## **Road restrictions**

## **Pedestrian Underpass**

**Have any details of the proposed upgrading of the underpass at High St been prepared?**

## **Accessibility**

High Street Underpass

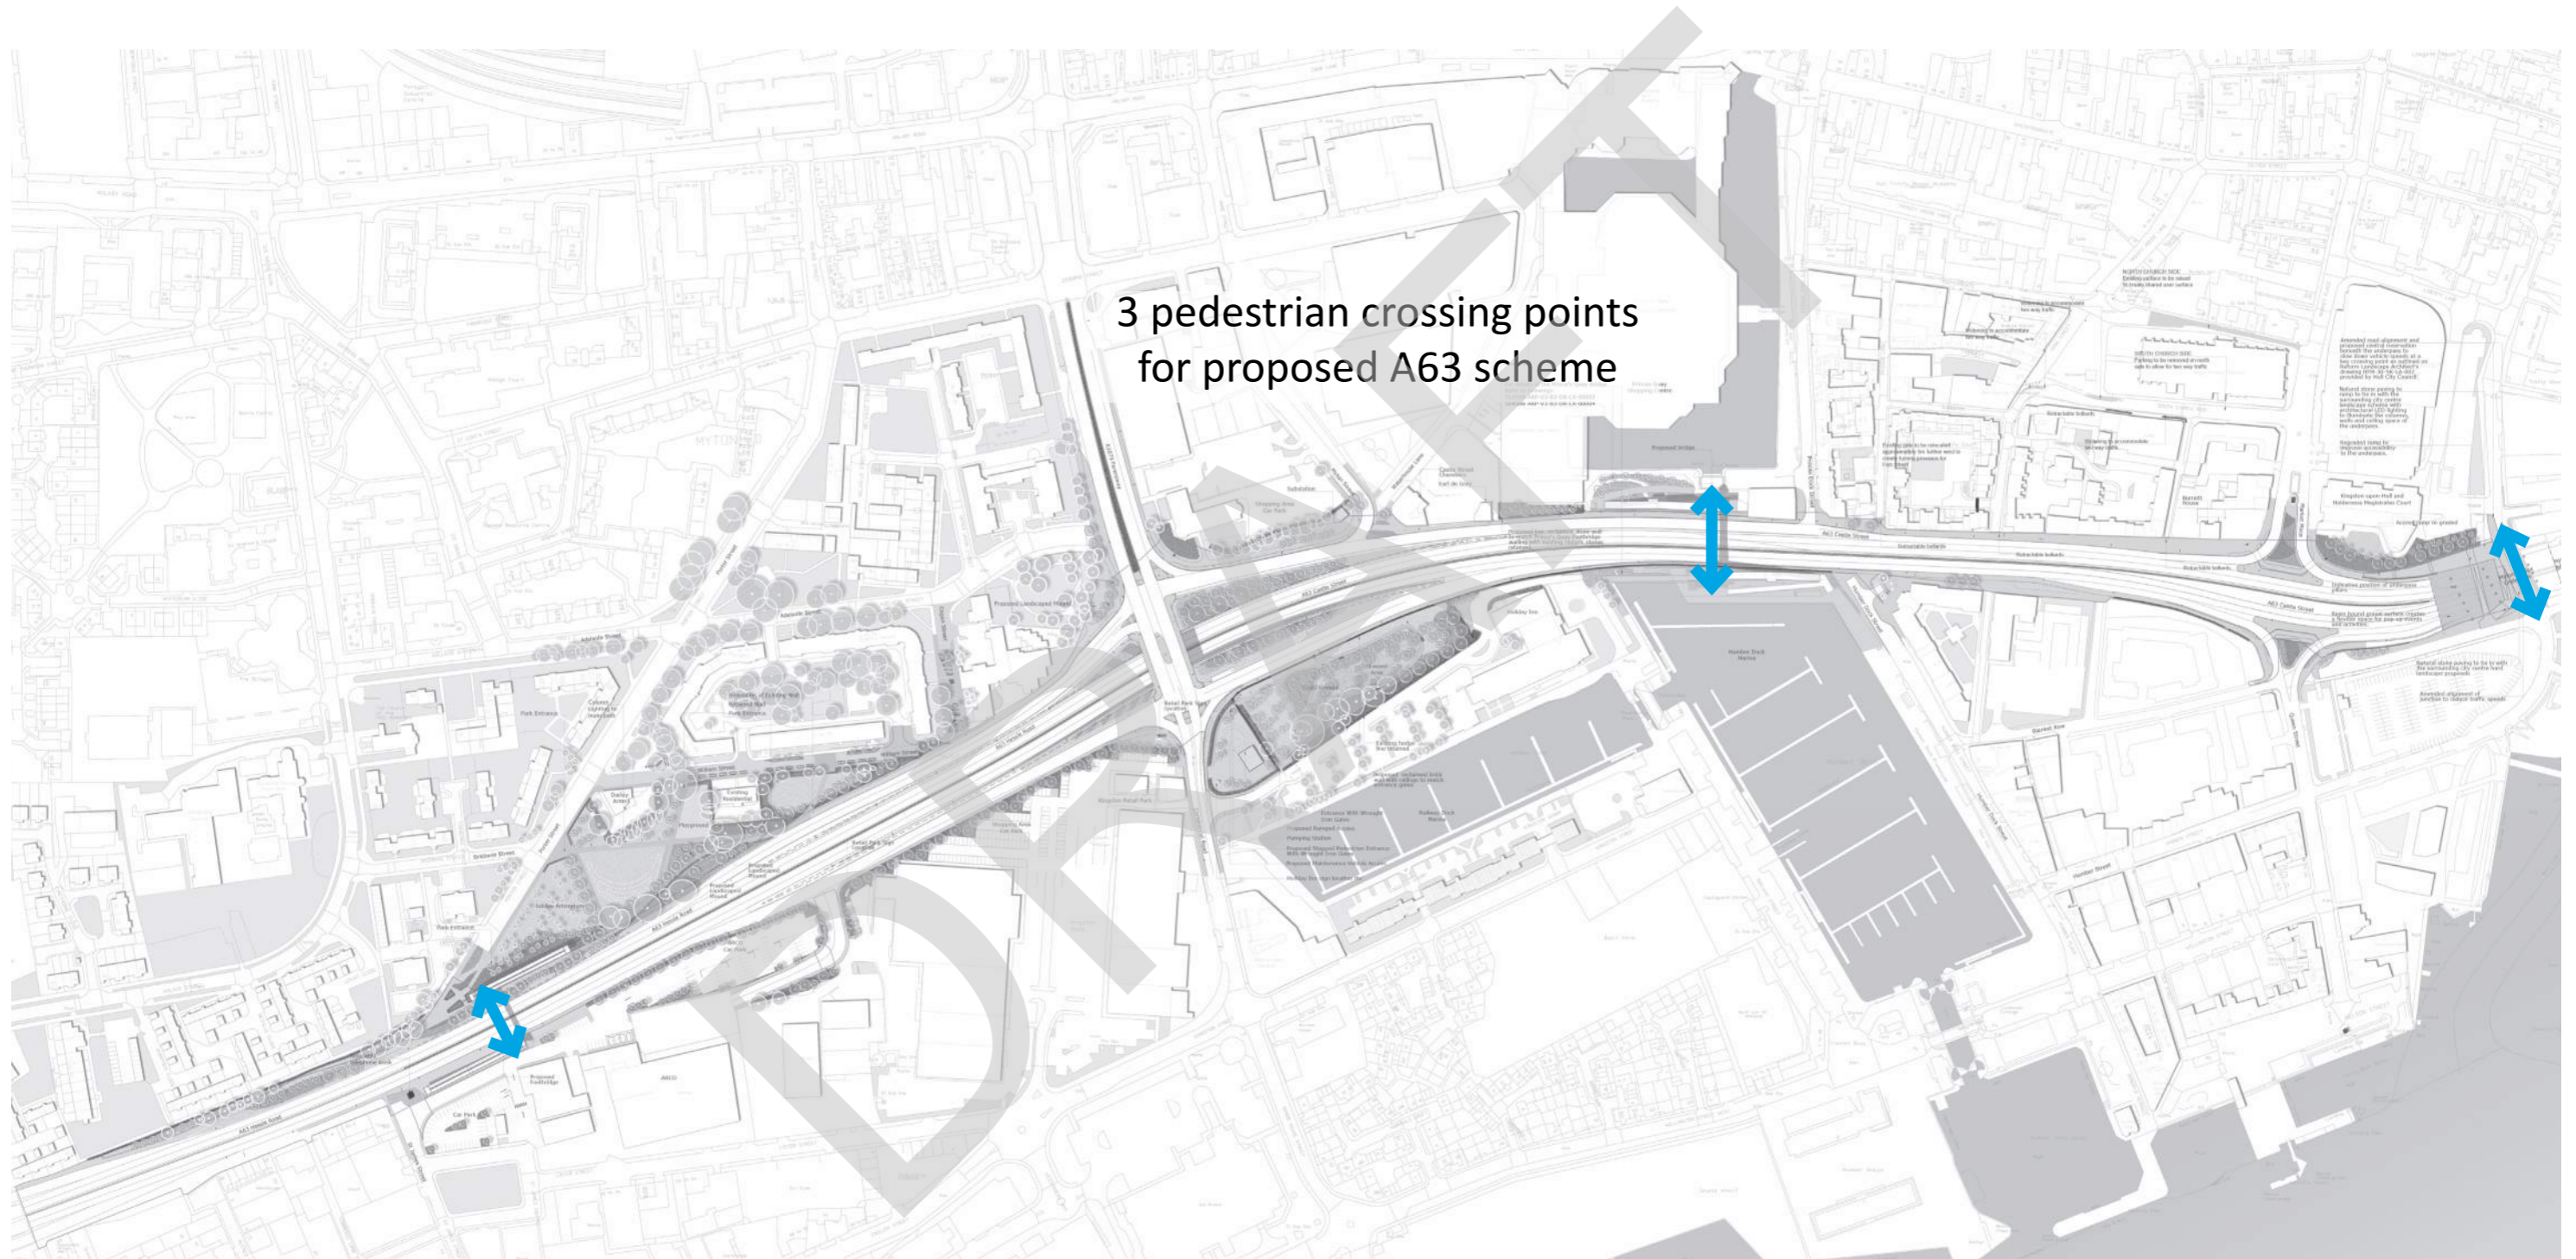
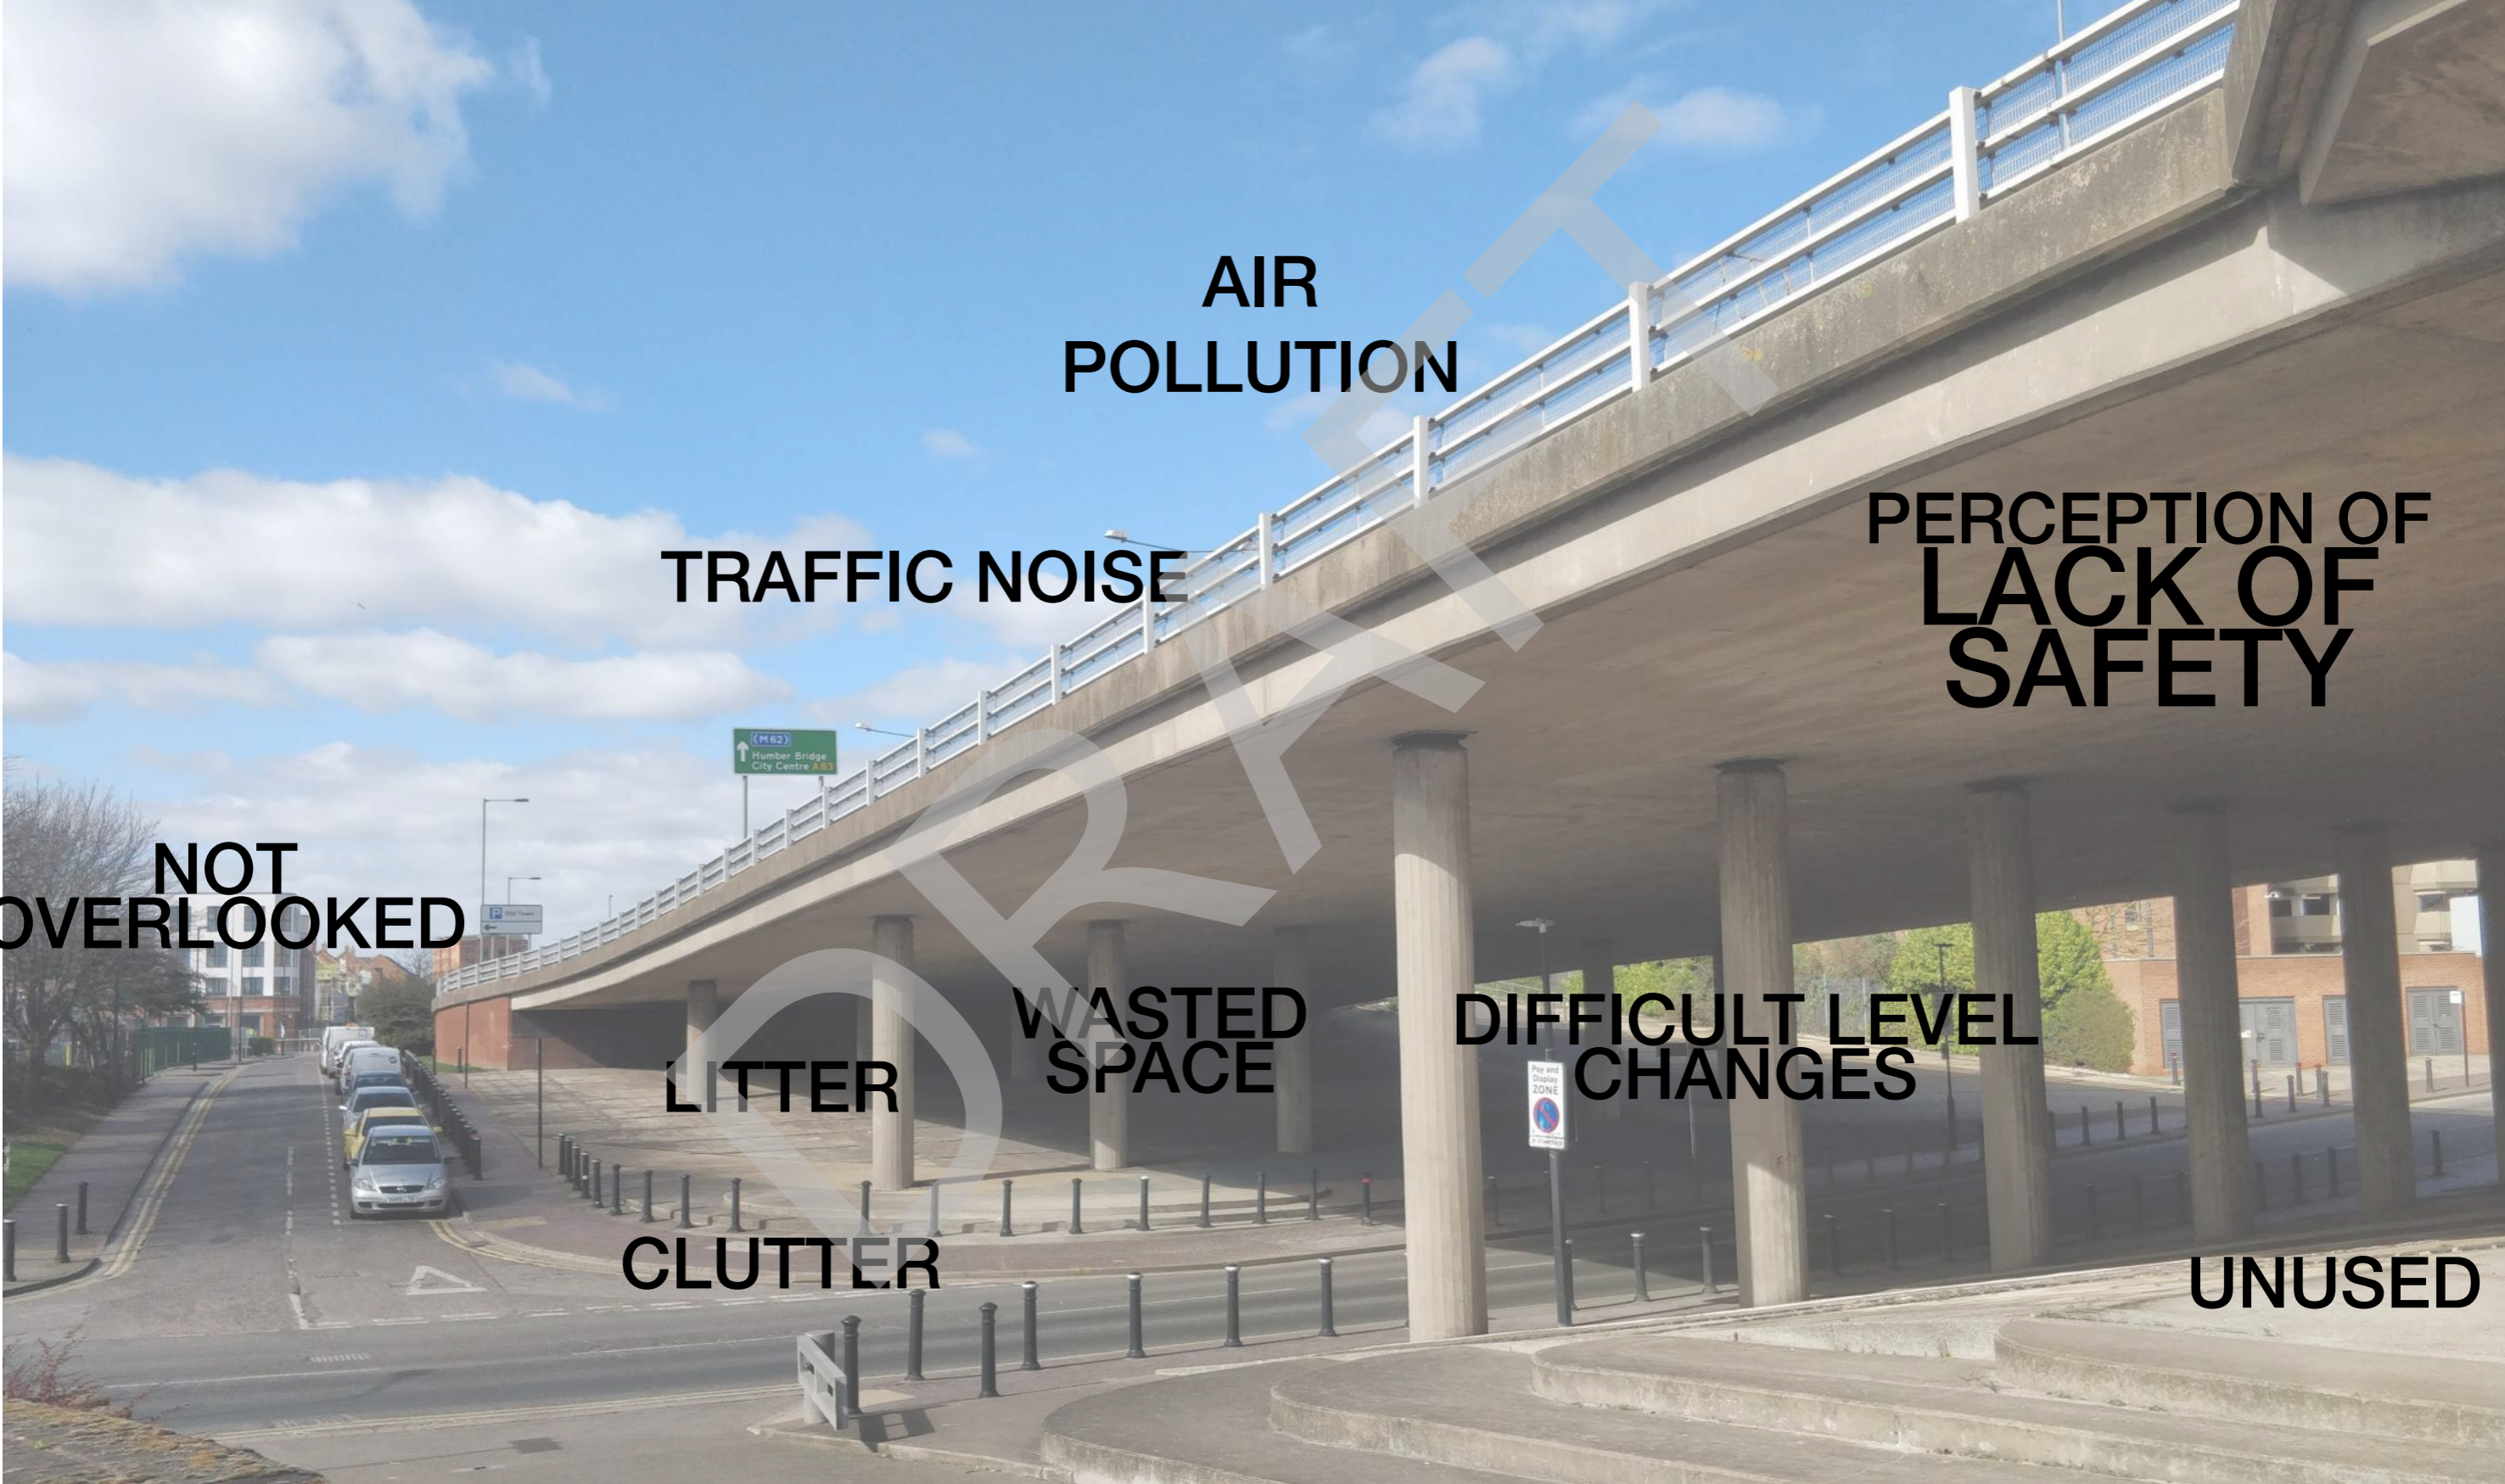
HAIG have been consulted on the proposed works and made suggestions to improve access. Meetings have been positive with the designers and Highways England engaging in constructive dialogue.

Looking at the design in isolation it works. But it cannot be looked at in isolation, it has to be seen in context of Castle Street and the travel distances involved by people using this route or the main bridge with its long ramps. Providing lifts to the main bridge must be added to the scheme to help reduce the travel distances.
